**Project Location: Whataburger – Volcano Rd. & 98<sup>th</sup> St.**  
**DRB Project Number: PR-2019-002402**

Bowman Consulting is in receipt of the comments dated March 16, 2022, issued by City of Albuquerque for the Whataburger restaurant at NEC of Volcano Rd. & 98<sup>th</sup> St, Albuquerque, NM 87121. Please see below for the responses to the comments:

## Transportation Development - Engineering Comments

DESIGN	DRAWN	CHKD
BB	BB	KAN
JOB No. 070426-01-001		
SHEET C007

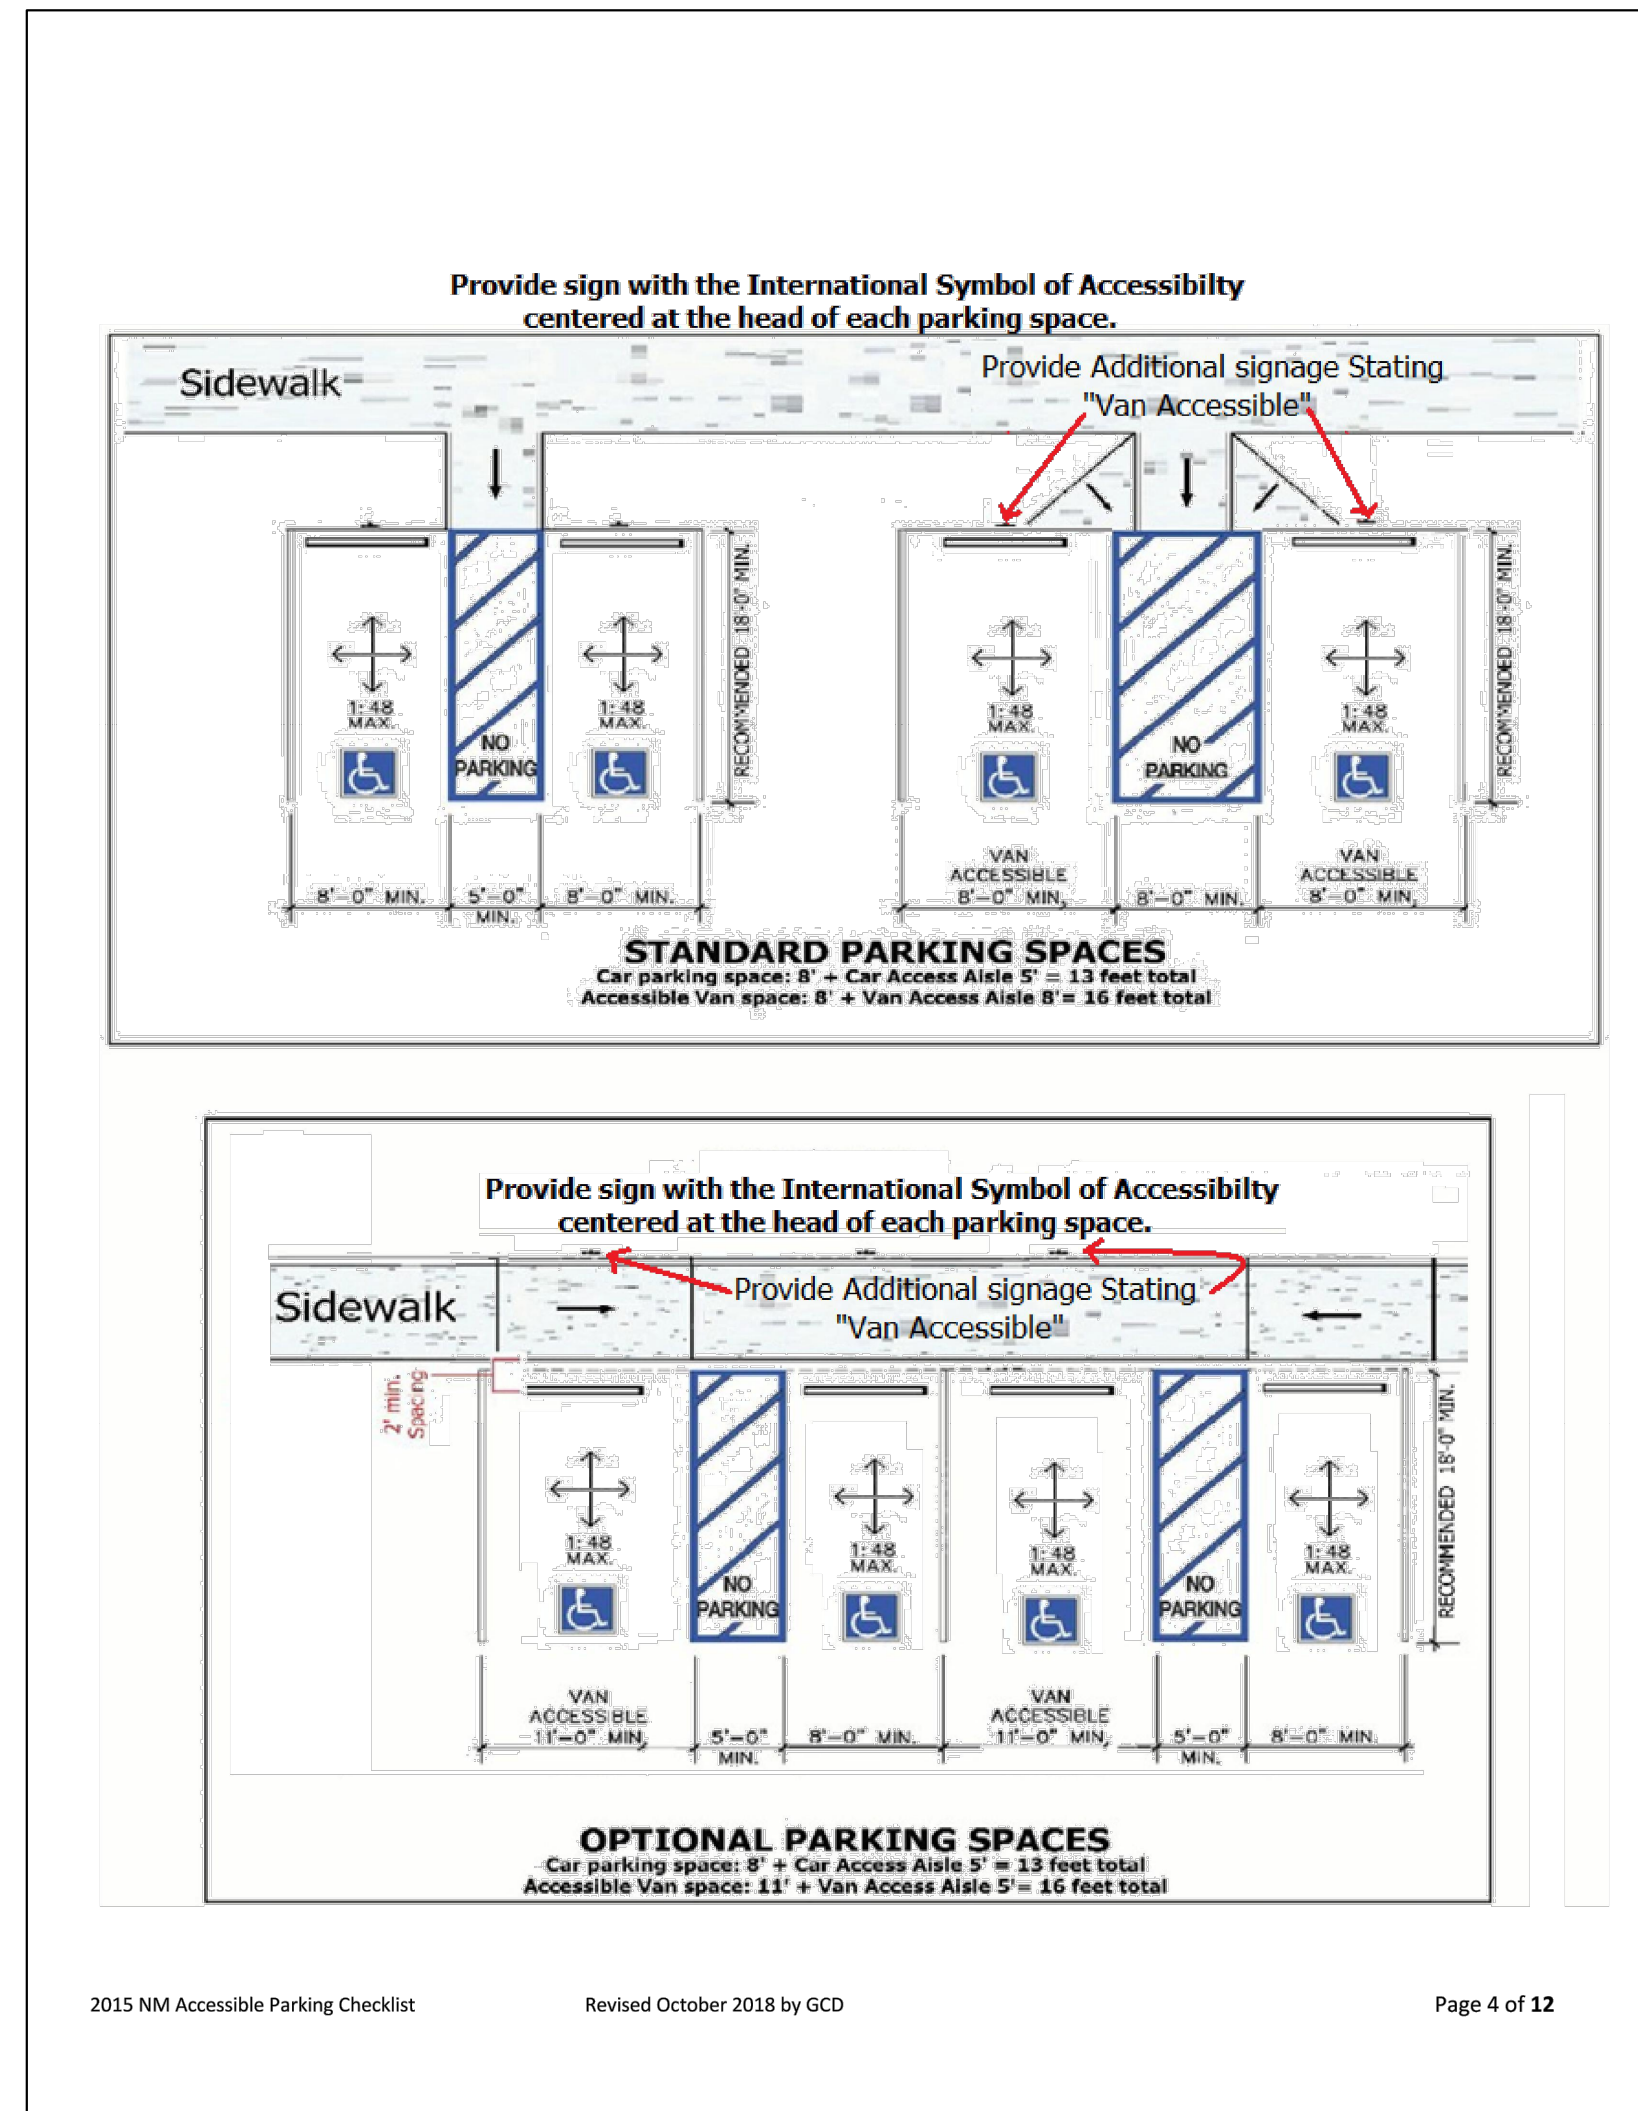
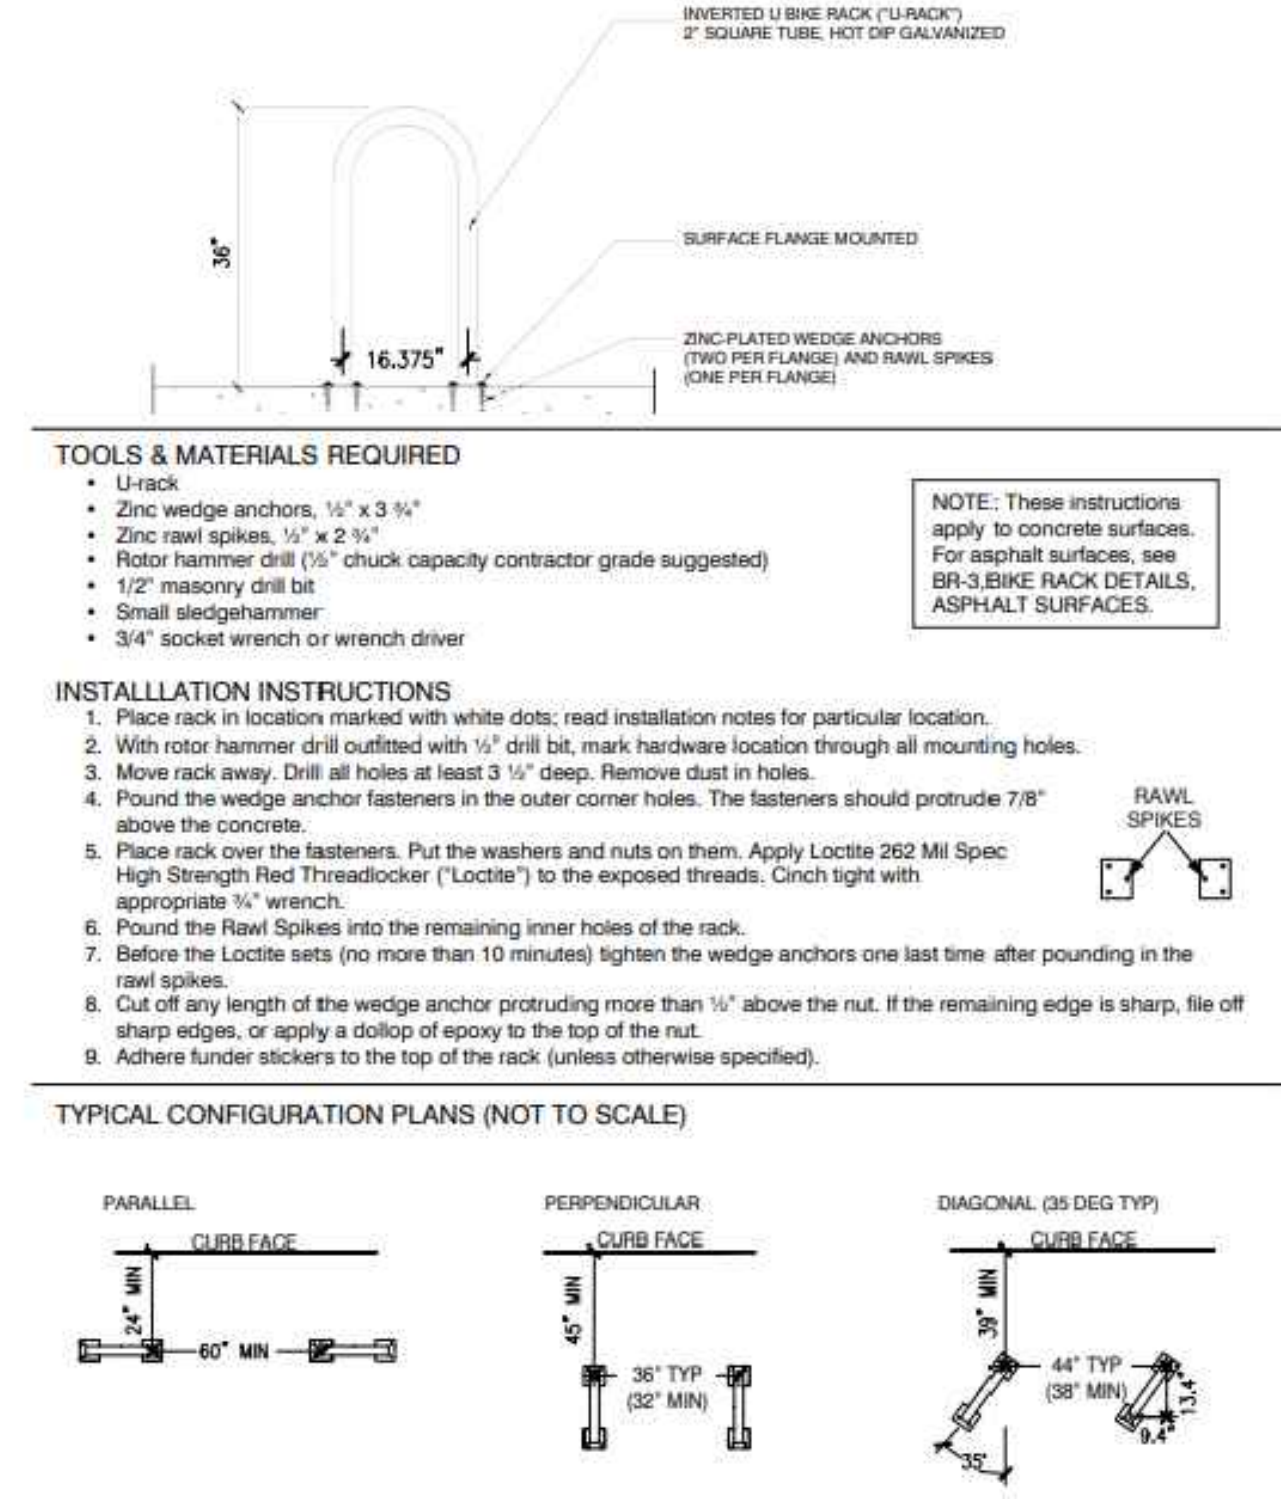
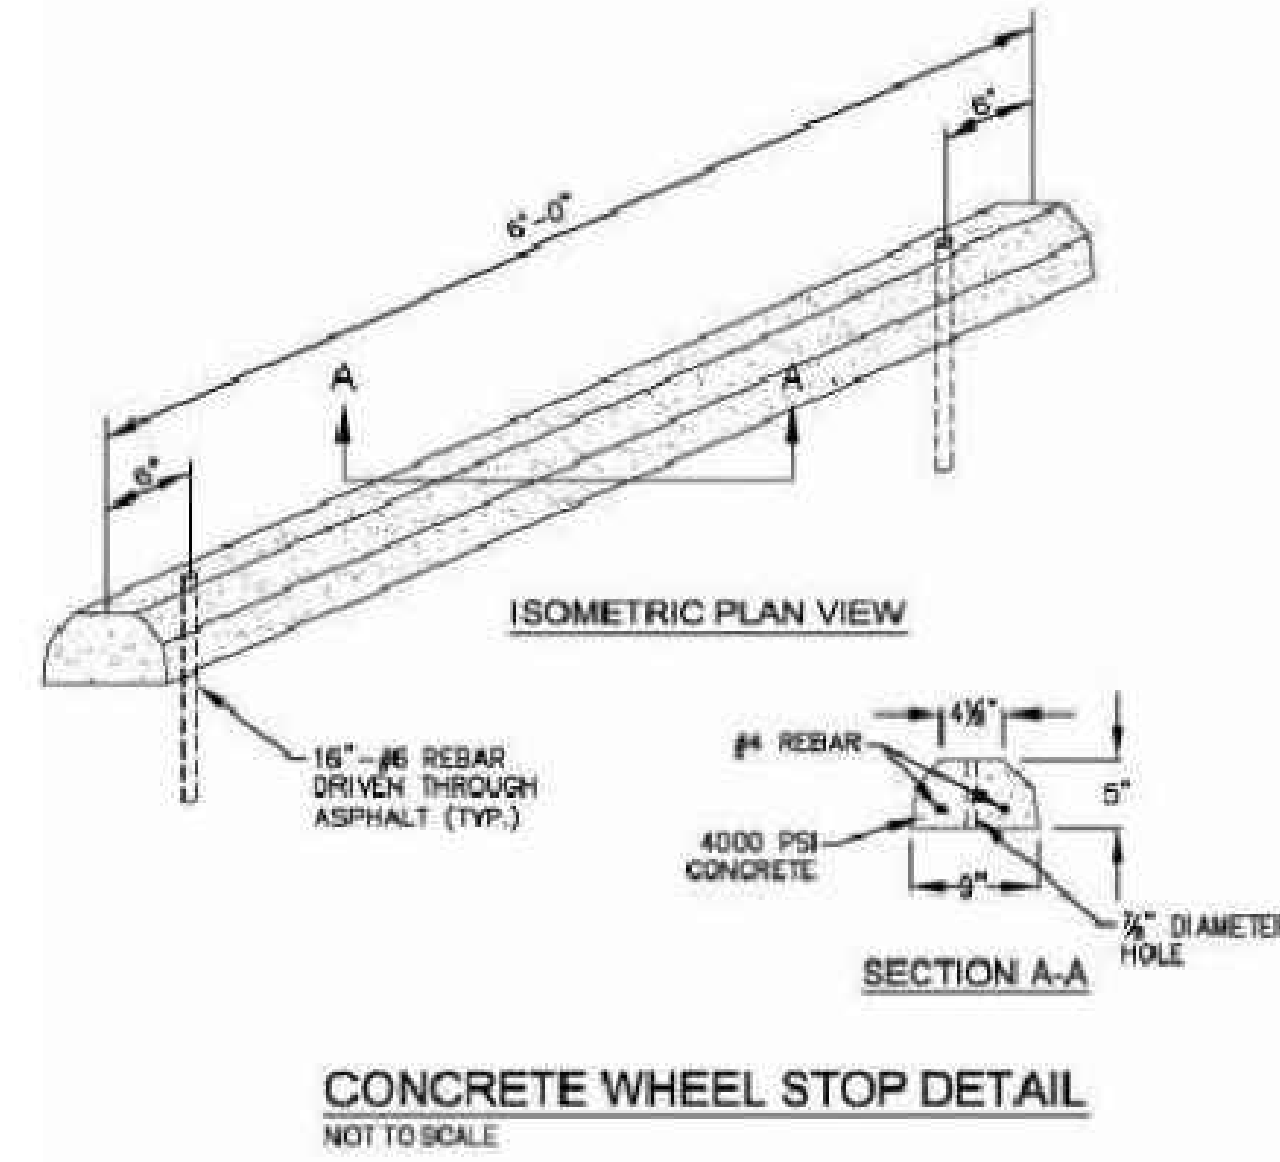
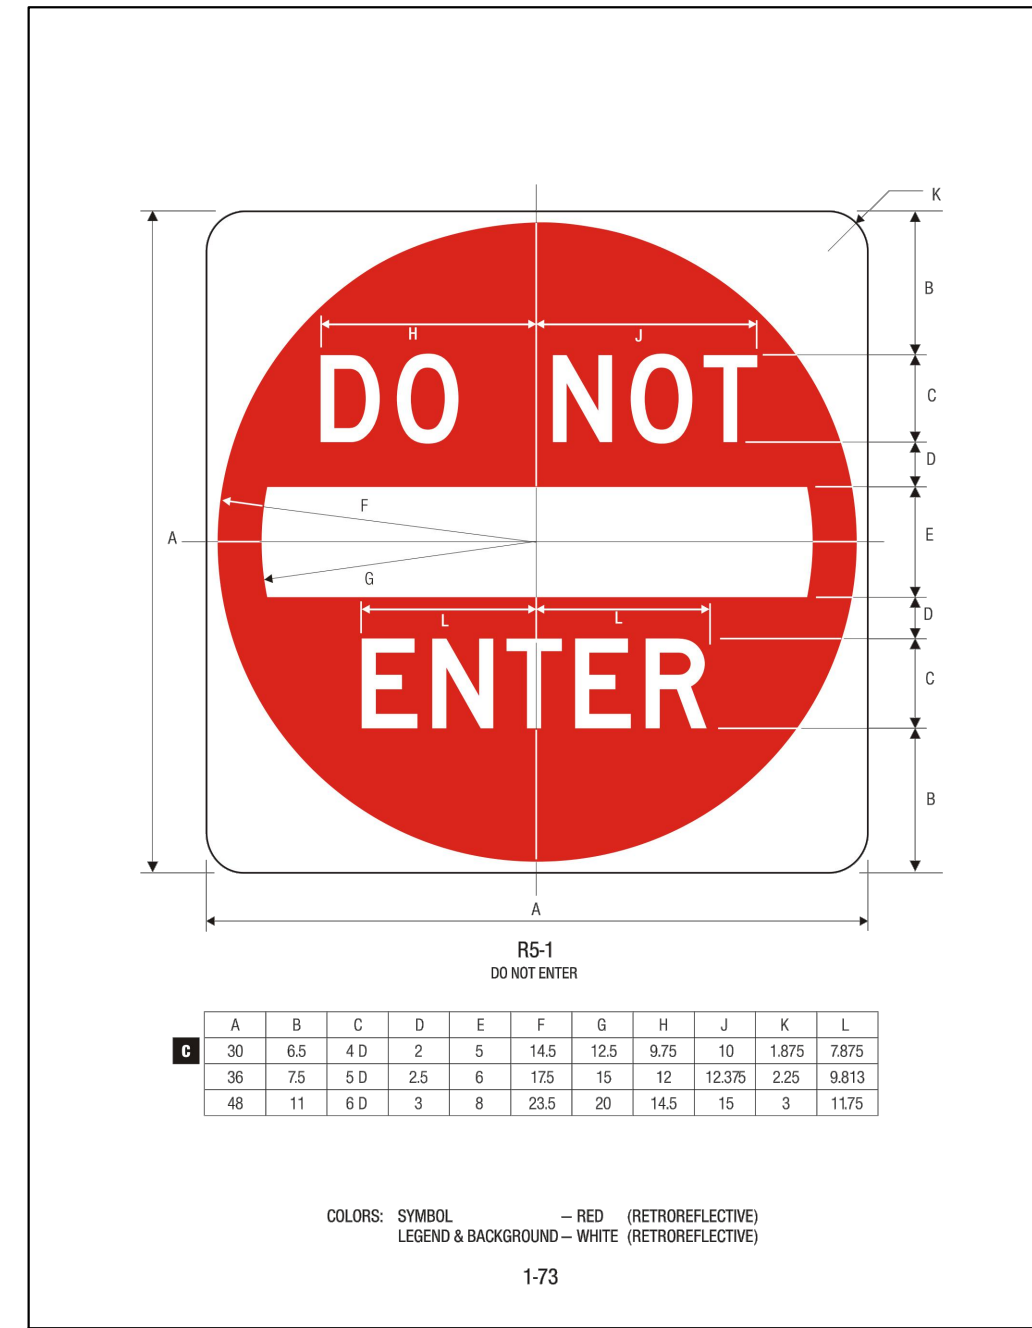
**Response: 2% cross-slope minimum labels have been added to sidewalk detail and site plan. Curb type has been labeled; see key notes.**
- Comment 5:** On 98th Street and Volcano, use a clear sight triangle for intersection sight distance to be sure that there are no conflicts with the proposed landscaping. Add the note "Landscaping, fencing and signing will not interfere with clear sight requirements. Therefore, signs, walls, trees, and shrubbery between 3 and 8 feet tall (as measured from the gutter pan) will not be acceptable in the clear sight triangle."

**Response: Sight distance triangles have been added to the site plan and landscape plan to confirm no landscaping, fencing and signage interfere with visibility.**
